Subdivision Comments

From: Holly Erdman, Environmental Health Specialist II

RE: LP-22-00002 Mohar Farm

PRELIMINARY MOHAR FARM CLUSTER PLAT

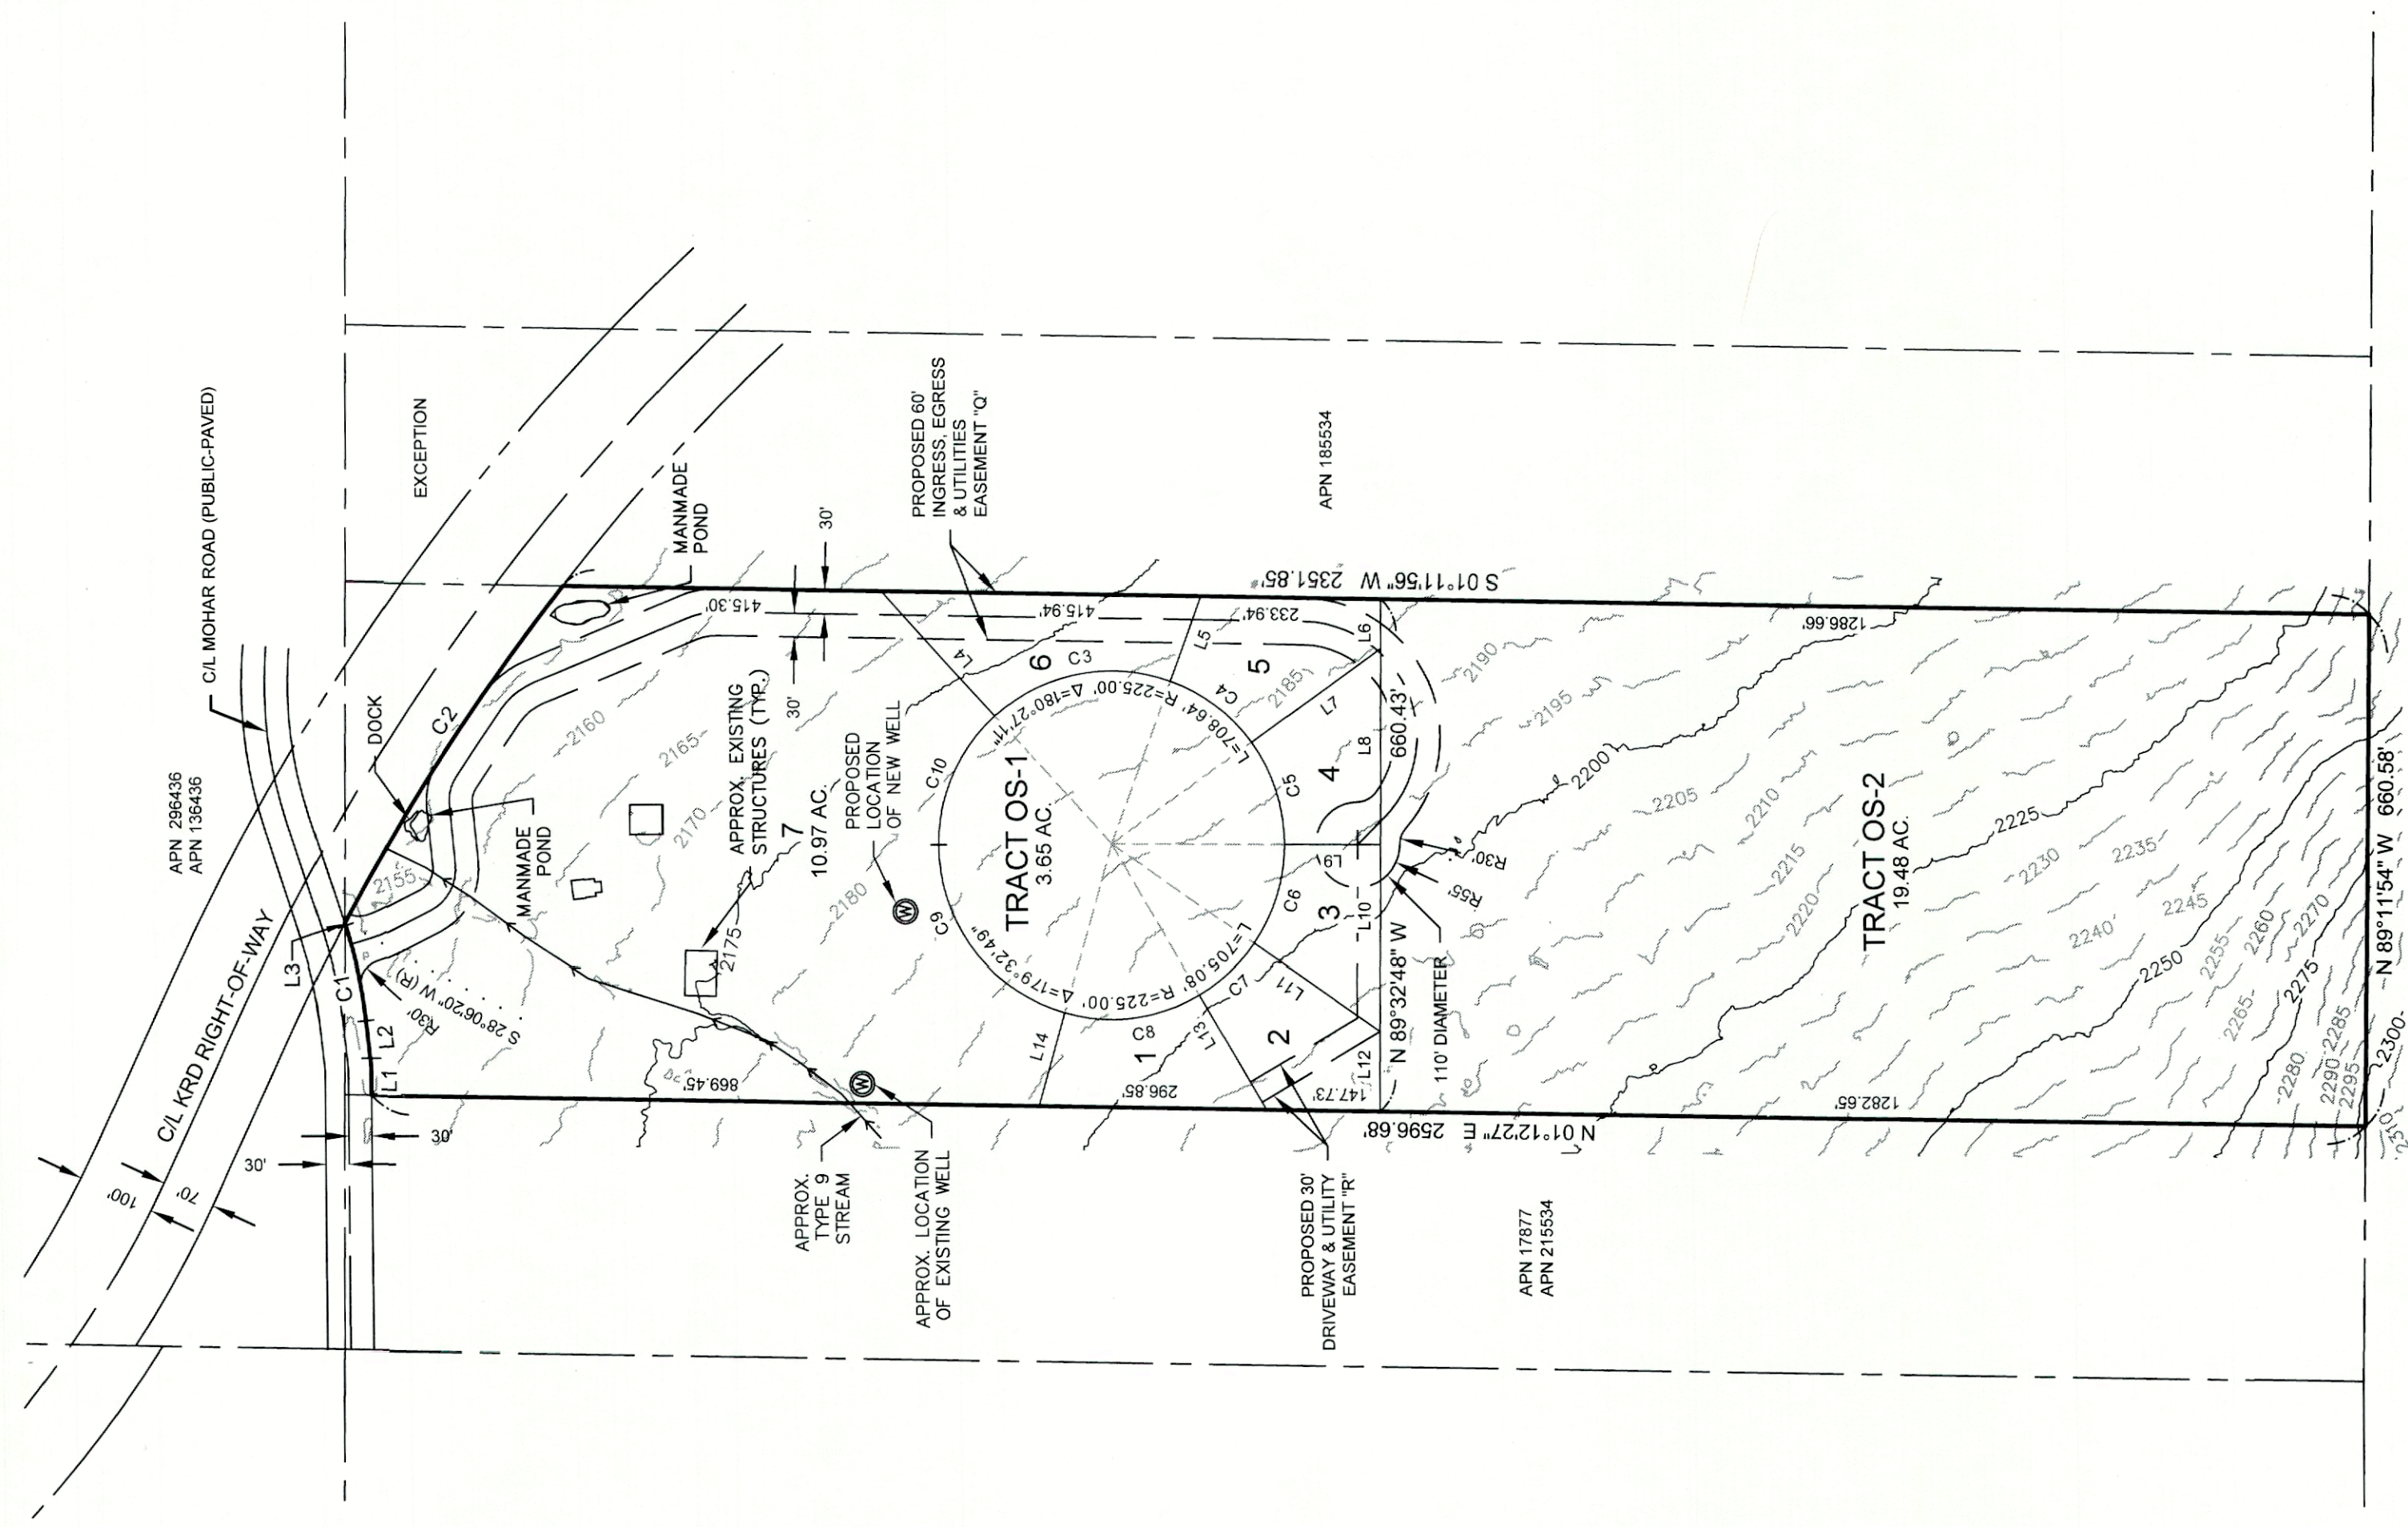
Any on-site septic systems that are to be utilized for wastewater management must adhere to the standards set by both the Washington Administrative Code, and Kittitas County Code. In accordance with KCC 13.04.090, a minimum of one soil log for each proposed lot where individual sewage disposal systems are contemplated must be completed.

The proposed long plat indicates the applicant will develop a Group B water system to serve the project. The location of the well site must be approved prior to drilling and a Group B water system must be approved by the Kittitas County Public Health Department. The applicant must prove legal and physical availability of water for all new uses of water on proposed lots.

A soil log must be done on each proposed lot.

A Group B public water system must be approved by the Kittitas County Public Health Department with a public water system ID# issued by the Washington State Department of Health, Division of Drinking Water.
